**Consultation Response from KC,
Highways Development Management****2025/92244 Trust Ford, St Andrew's Road, Huddersfield, HD1 6RJ****Extension of hardstanding to increase area of parking and used car display****Date Responded: 30-09-2025****Responding Officer: D. Stainsby****Responding Ref: K5-11NW/26**

Application for the extension of hardstanding to increase area of parking and used car display at Trust Motors, St Andrew's Road, Huddersfield

TITLE: Proposed Site Plan (Part) 1 of 2  
 & Existing Site Plan (Part)

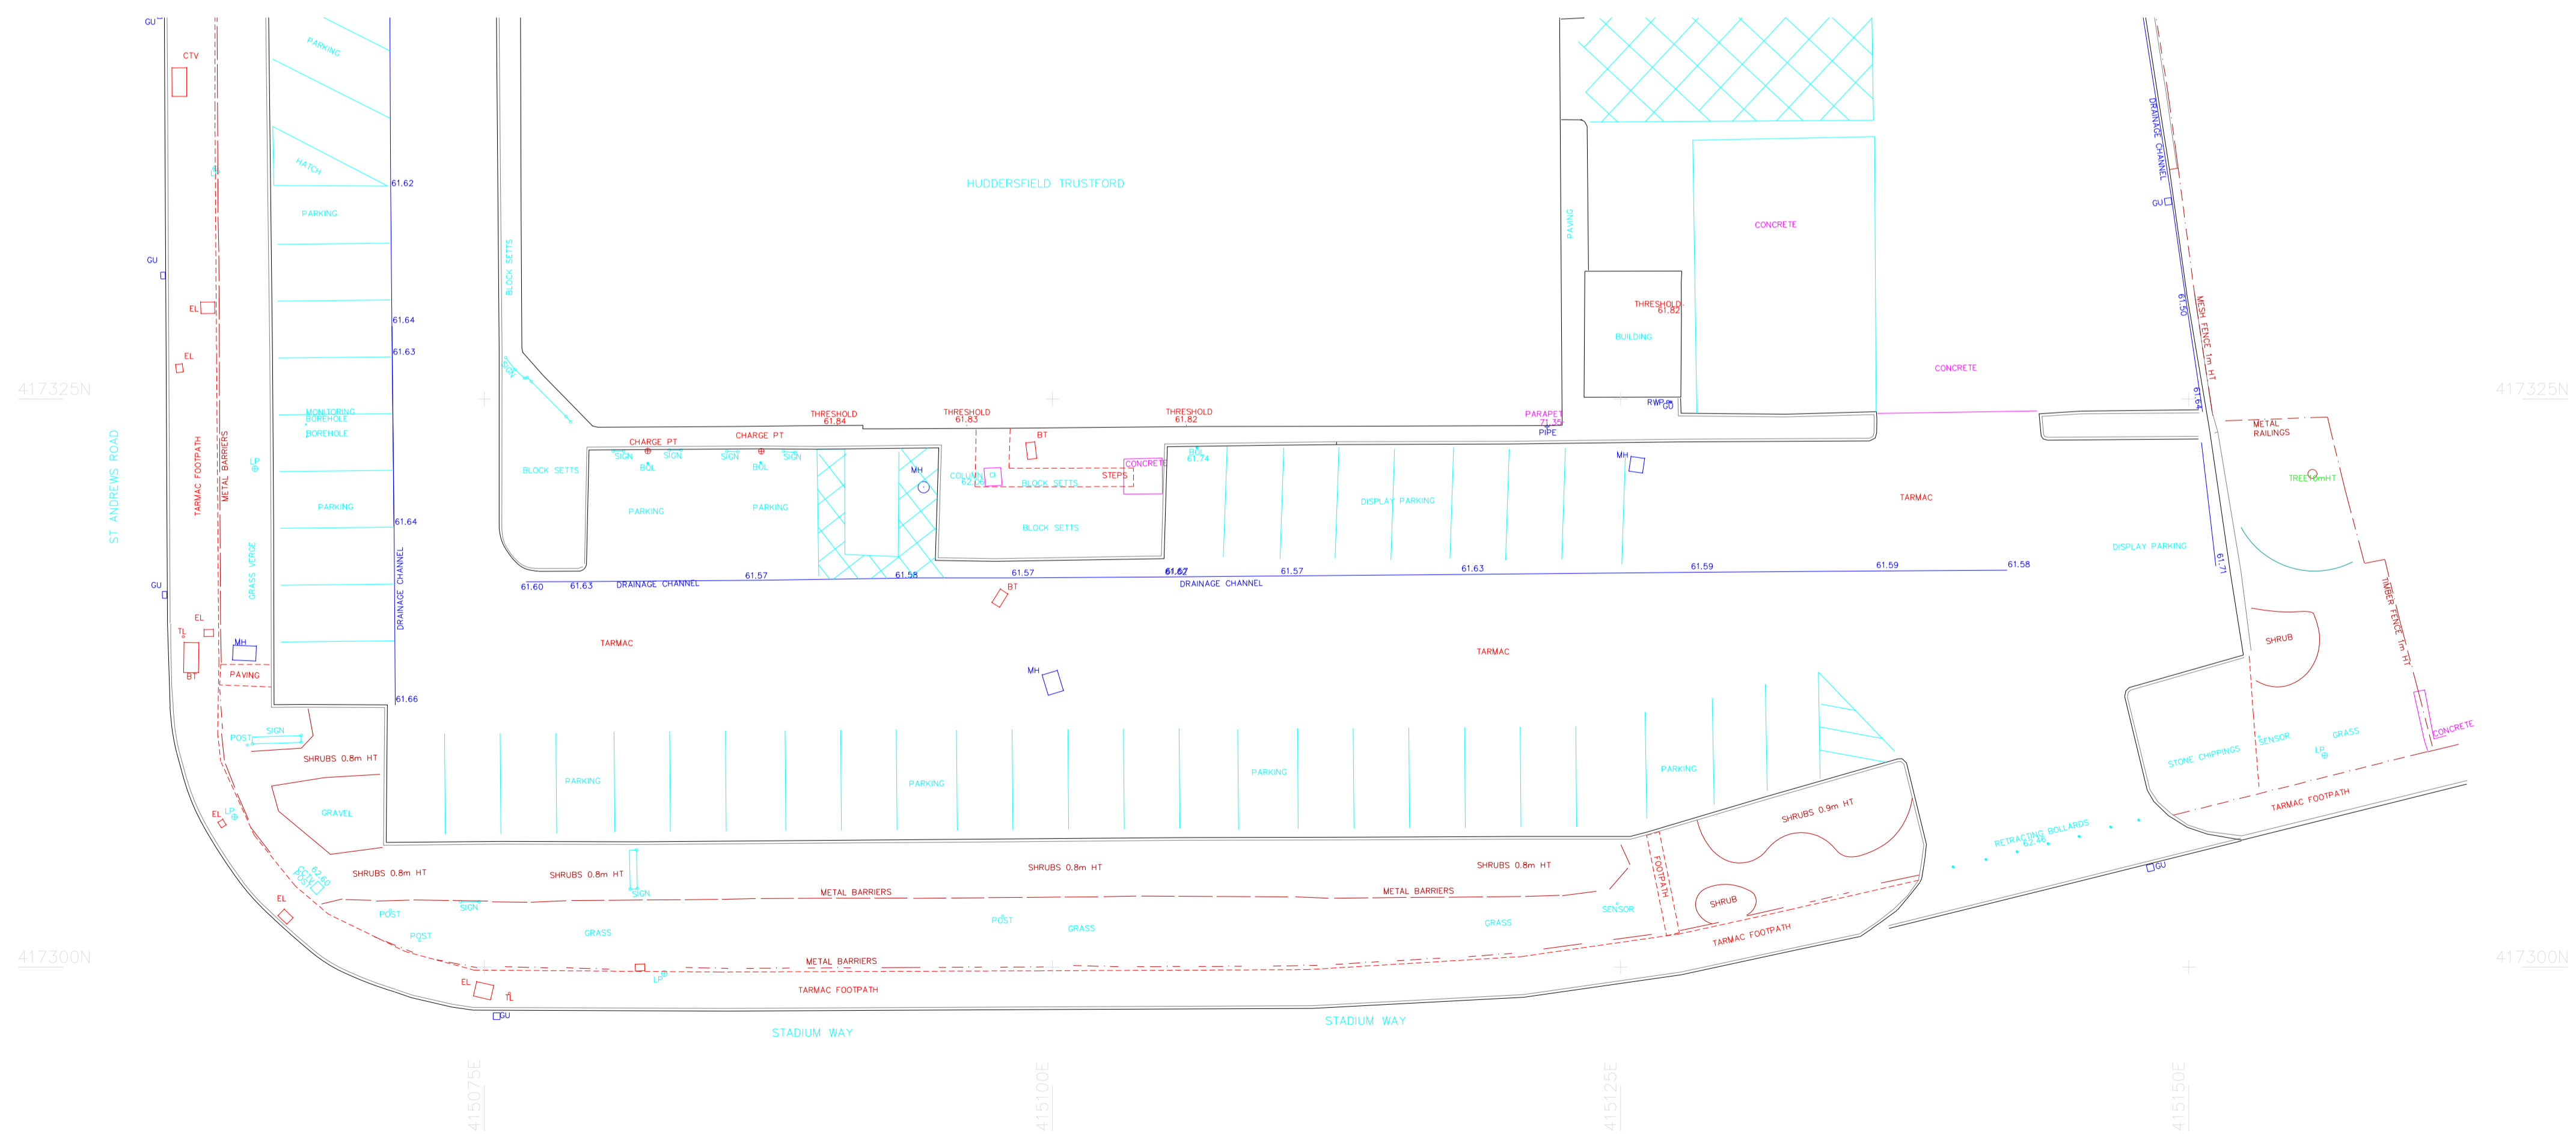
The proposal does not increase the use of the site and the vehicle accesses to the site will remain as existing and are unaffected by the proposals.

The additional car parking spaces are proposed for display vehicles and are acceptable.

The approved vehicle parking areas will need to be surfaced and drained in accordance with the Communities and Local Government; and Environment Agencies 'Guidance on the permeable surfacing of front gardens (parking areas)' published 13th May 2009 (ISBN 9781409804864) as amended or superseded.
